Sent: 15 December 2013 15:09
To: Planning
Subject: Welwyn Hatfield Council Online Planning - Comment

Application Number: S6/2013/2381/FP
Name: Ian Harrison
Address: 13 Ramsey Close
BrookmansPark Hertfordshire
Comment Type: Observation

Drawing: **Block Plan**

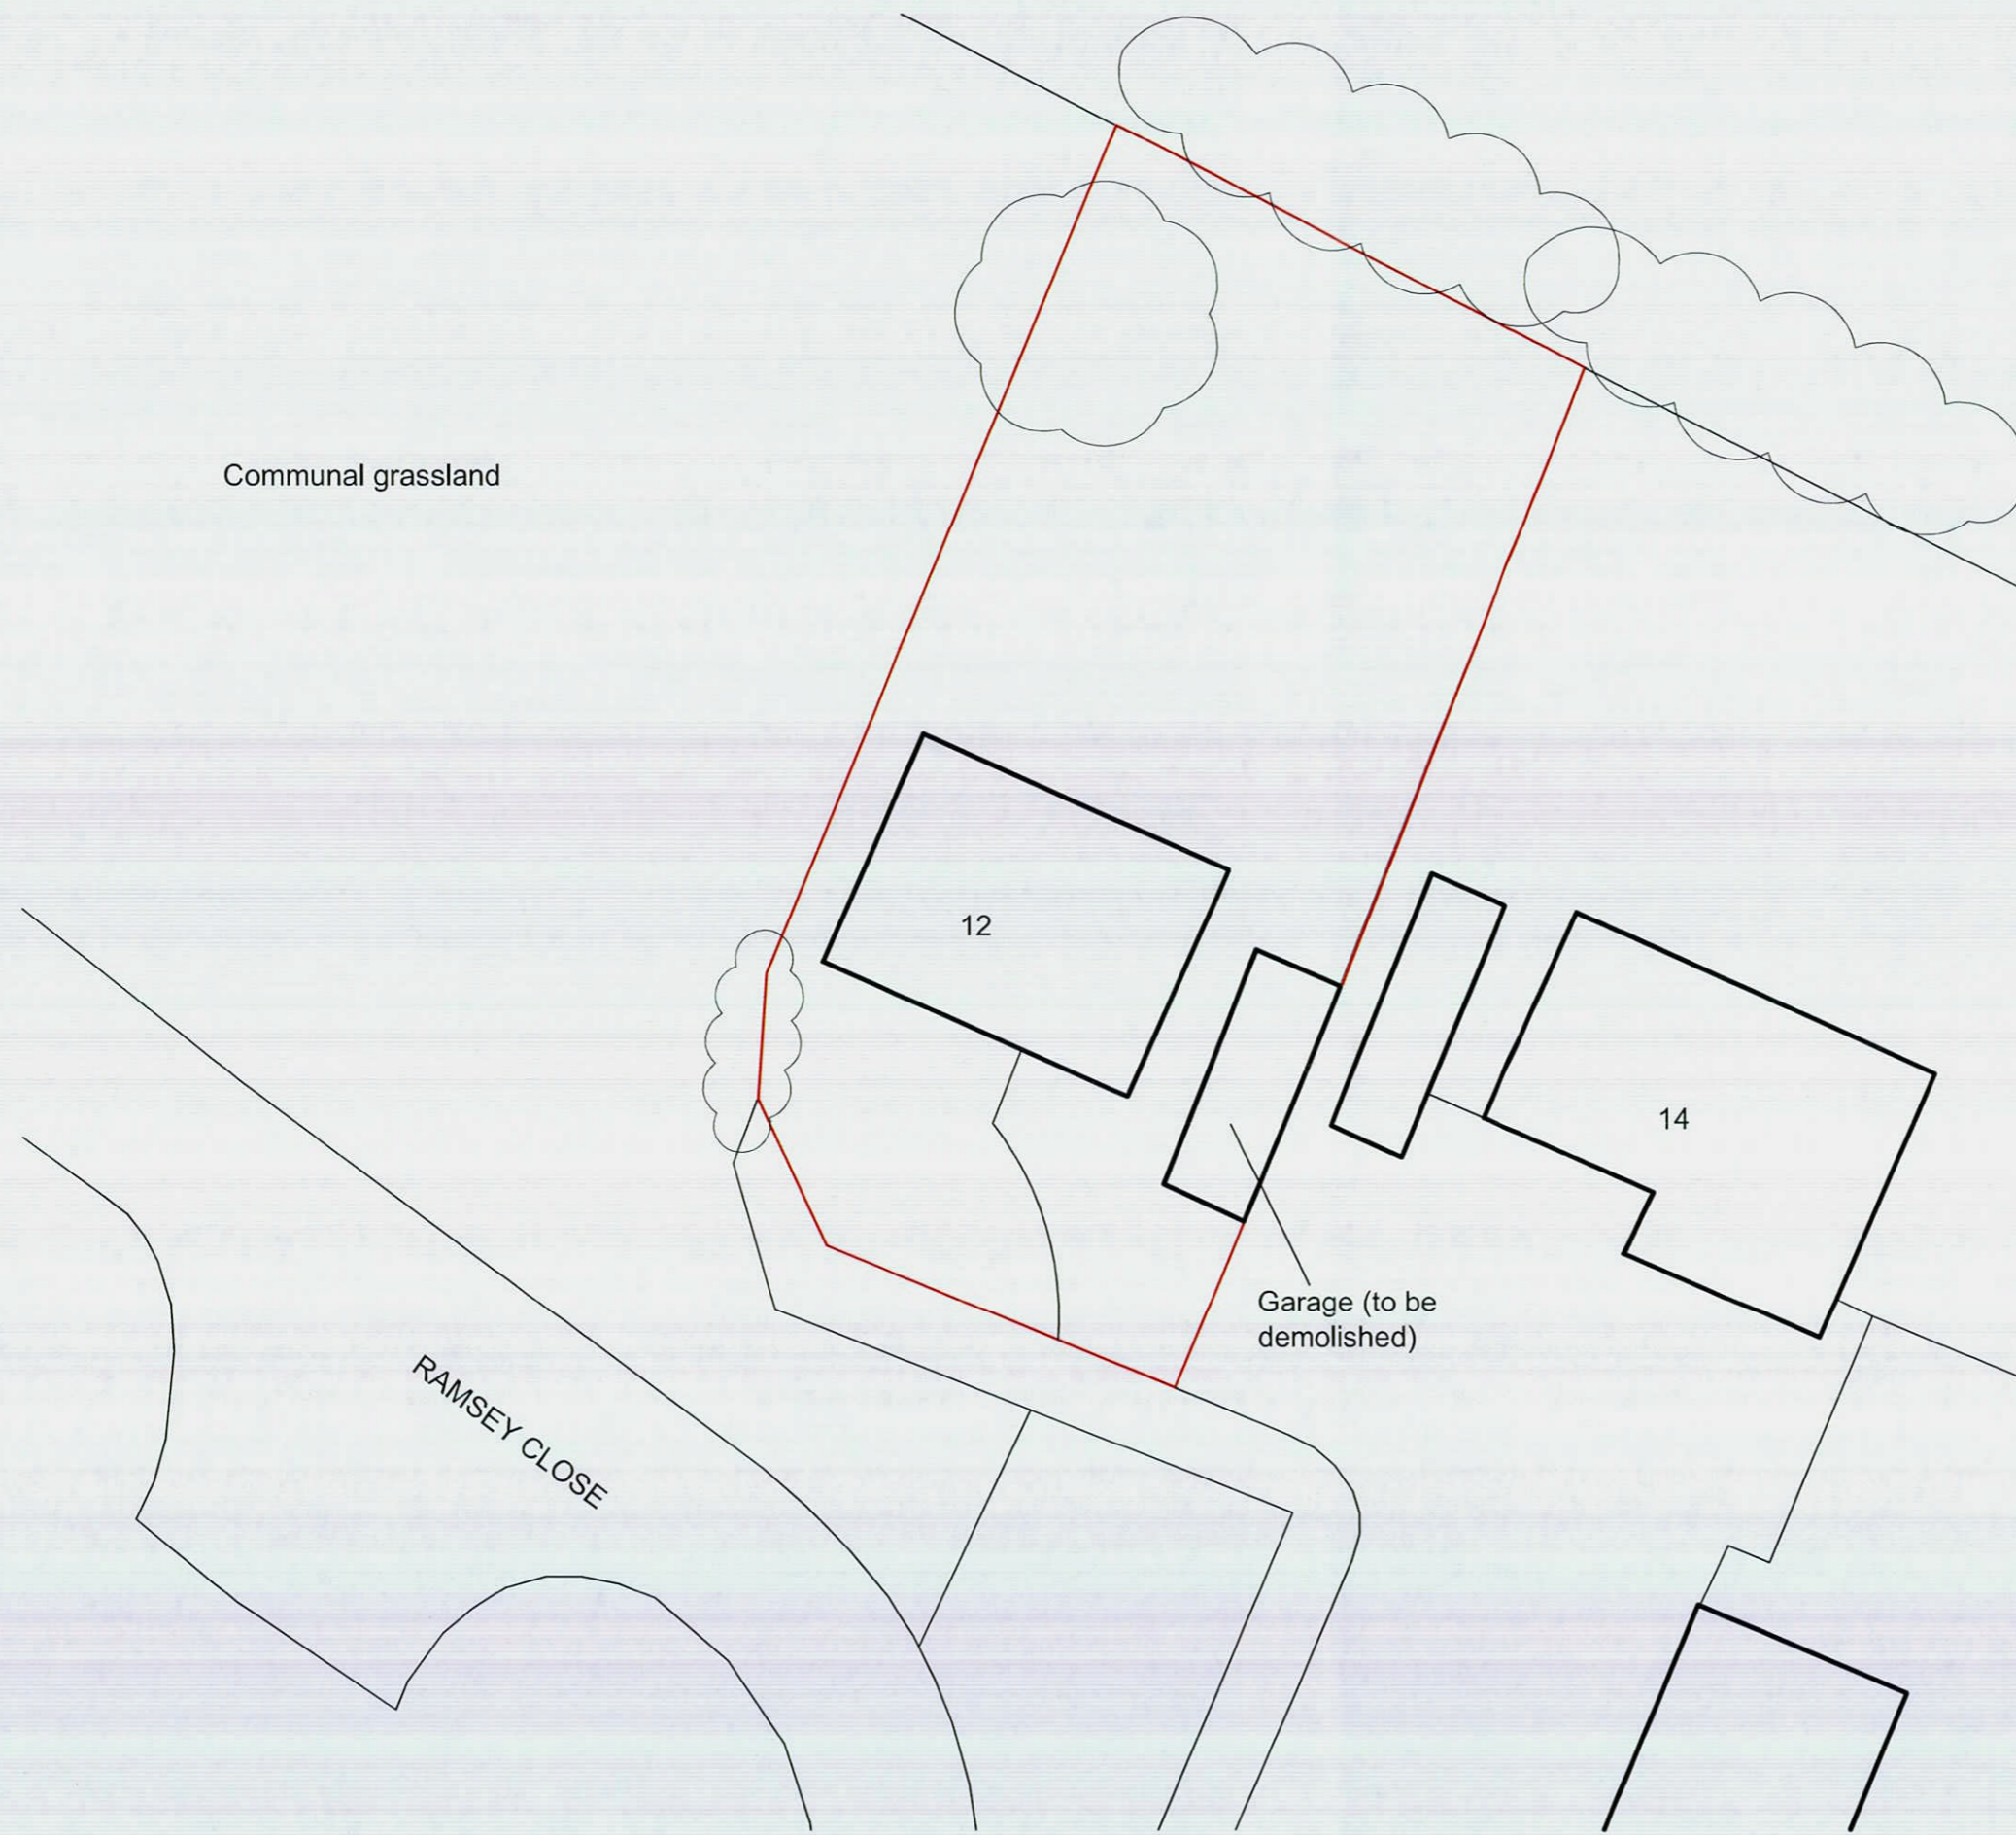
Comment: The submitted drawings show that the extended dwelling would provide a total of four bedrooms. The Parking Standards Supplementary Planning Guidance (SPG) identifies the site as within Zone 4 where residential dwellings with four or more bedrooms require a maximum of three car parking spaces which can be provided within the site. By reducing the possible parking spaces in front of the house I am unsure where these three parking spaces are going to come from? There are four "visitor" spaces presumably shared by the four houses on the close. These spaces may now have to house a 3rd car. This will clearly impact on parking within the close. I therefore agree with the observations previously submitted and ask that this is taken into consideration when making your decision.
